CITY OF ALBUQUERQUE

**Re: Unser Crossing- Building B
10621 Unser Blvd NW
Request for Certificate of Occupancy-30 Day Temp
Transportation Development Final Inspection**
Architect's Stamp date 7-20-21 (A11D017B)
Certification dated 2-27-24

SHEET NUMBER
AS-1.1

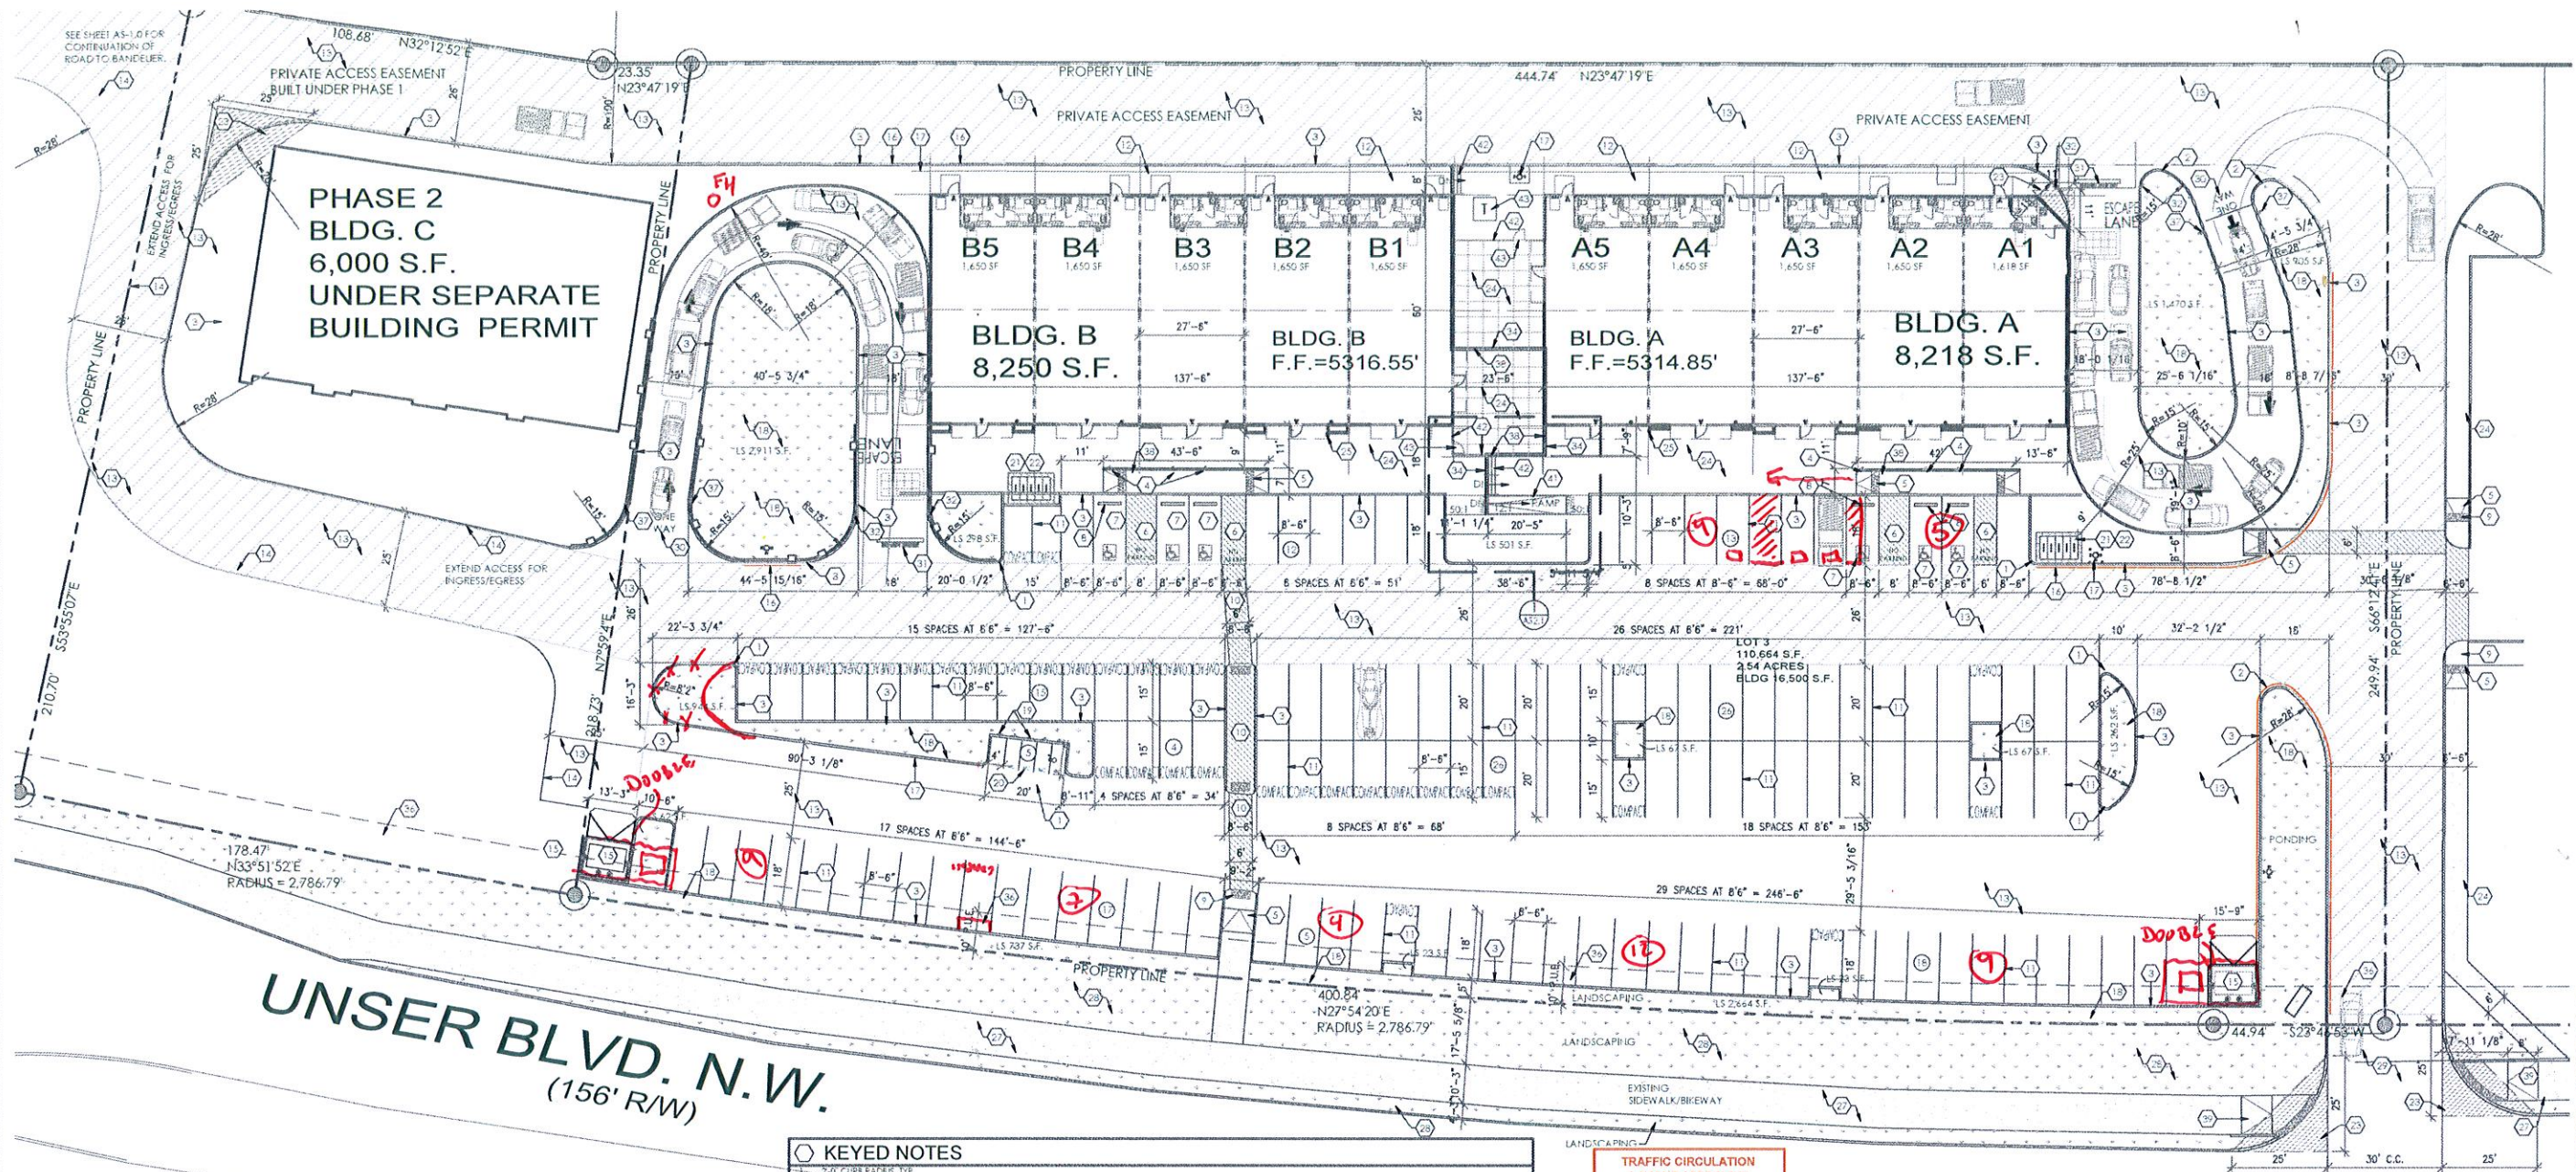
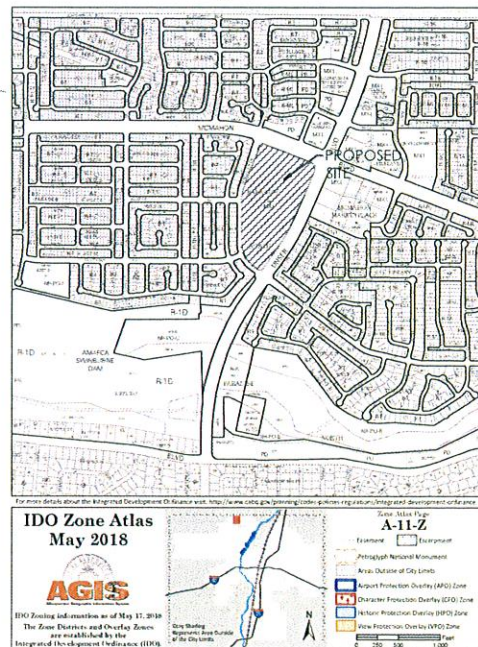
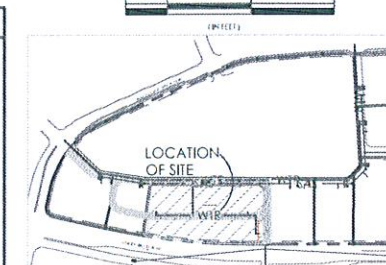
1. The installed size of each bike rack was not per plan: 14" wide.
2. The installed spacing between bike was not spaced per plan: 16" apart.
3. The drive-up was missing the "Do Not Enter" and One-Way" pavement markings.
4. The asphalt at the south edge of the site, east of the drive through, terminated into uneven dirt with piles of concrete and asphalt debris and the asphalt drive through the area labeled "Phase 2 Bldg C" was not constructed.
